**Consultation Response from KC,
Trees**

2025/92713 Rear of, 23 to 43, Moor Lane, Gomersal, Cleckheaton, BD19 4LF

Reserved matters application pursuant to outline permission 2023/92079 for erection of residential development of 10 dwellings, demolition of existing extension at 27 Moor Lane, widening of existing access and realignment of boundary walls and discharge of details reserved by conditions 4 (noise), 5 (BEMP), 6 (Arboricultural Impact Assessment), 7 (safety and security), 8 (landscape), 9 (LEDS)

Date Responded: 04/11/2025

Appendix 2: Draft tree protection plan

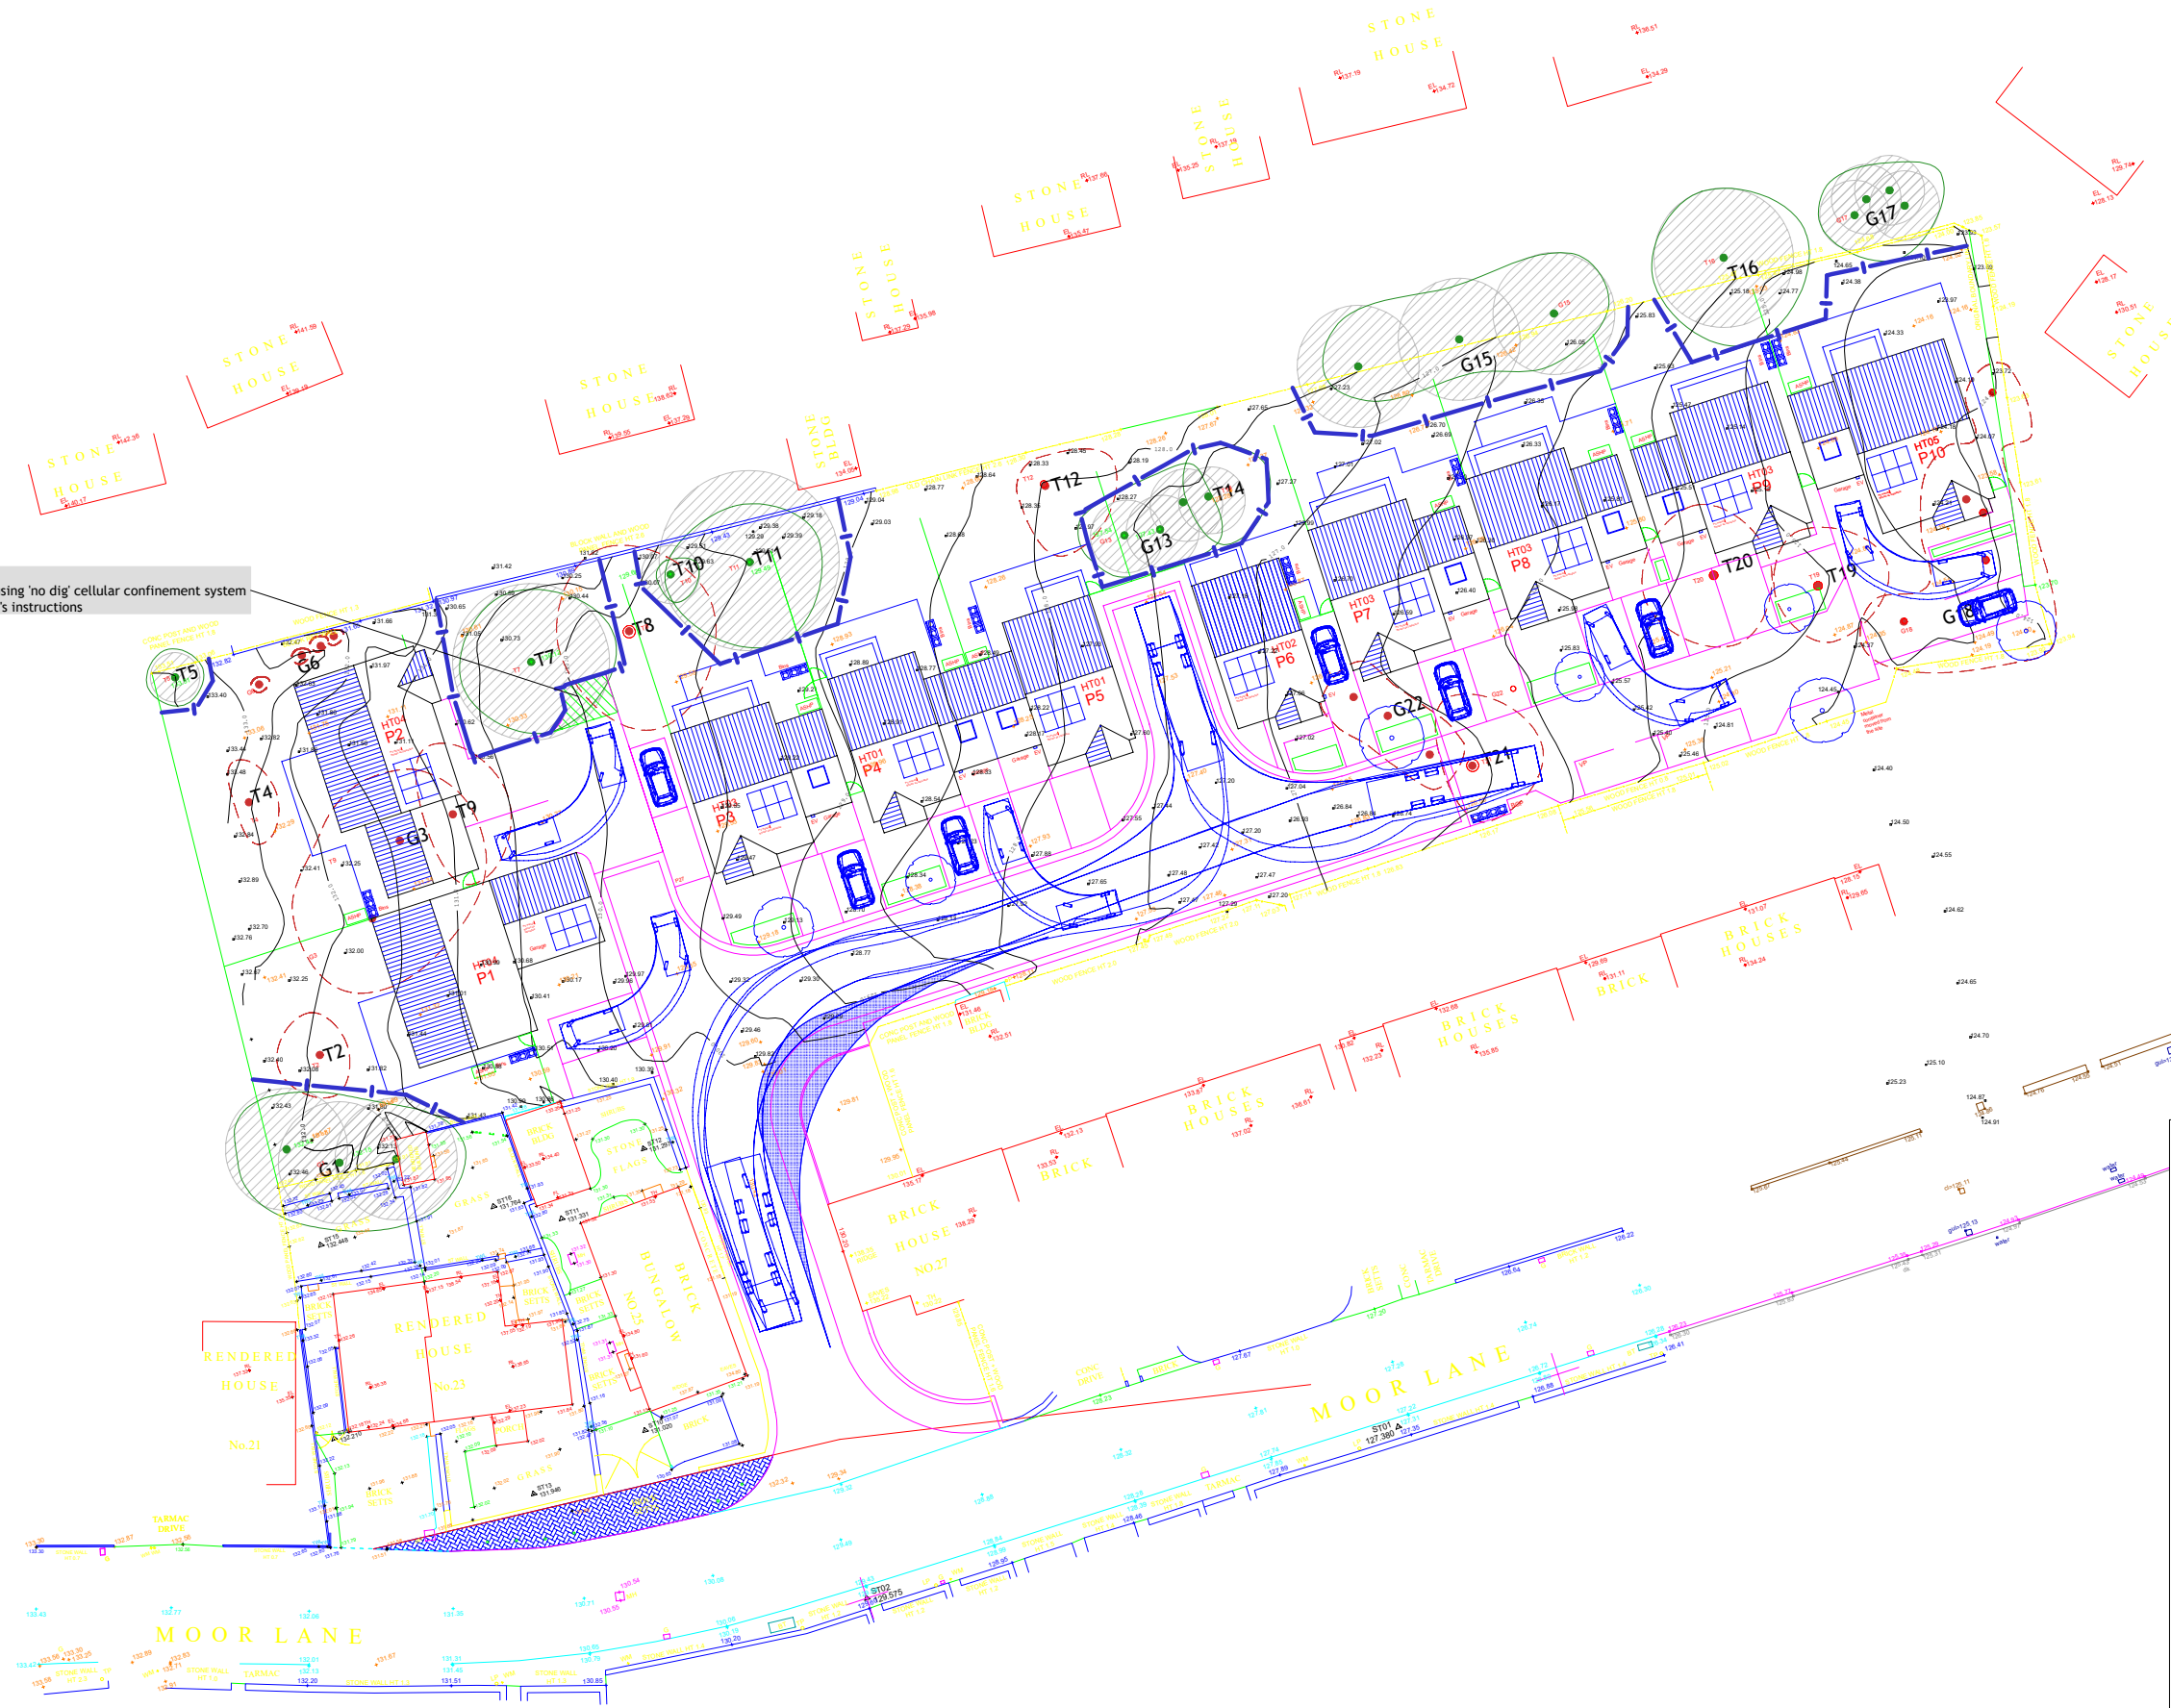
Condition 6 (Arboricultural Impact Assessment) has been satisfied.

The draft tree protection plan looks good, there are no objections to the proposals from an arboricultural perspective. However given that the site has protected trees (TPO 46/96) along its northern boundary, which will be retained in proximity to the construction the following documents must be submitted and approved by Kirklees Council:

- An Arboricultural Method Statement in line with BS5837, to demonstrate that proposed operations can be undertaken with minimal risk of adverse impact to the trees to be retained. To include, but not limited to, special engineering within root protection areas and other relevant construction details, any site monitoring and a timeline of proposed operations.
- A Tree Protection Plan which is superimposed on to a layout plan based on a topographical survey and tree survey. This should include the precise location of protective barriers, the extent of any ground protection, and additional measures that will be installed to safeguard trees and their root protection areas.
- A schedule of works, to include facilitation pruning and any landscaping details.
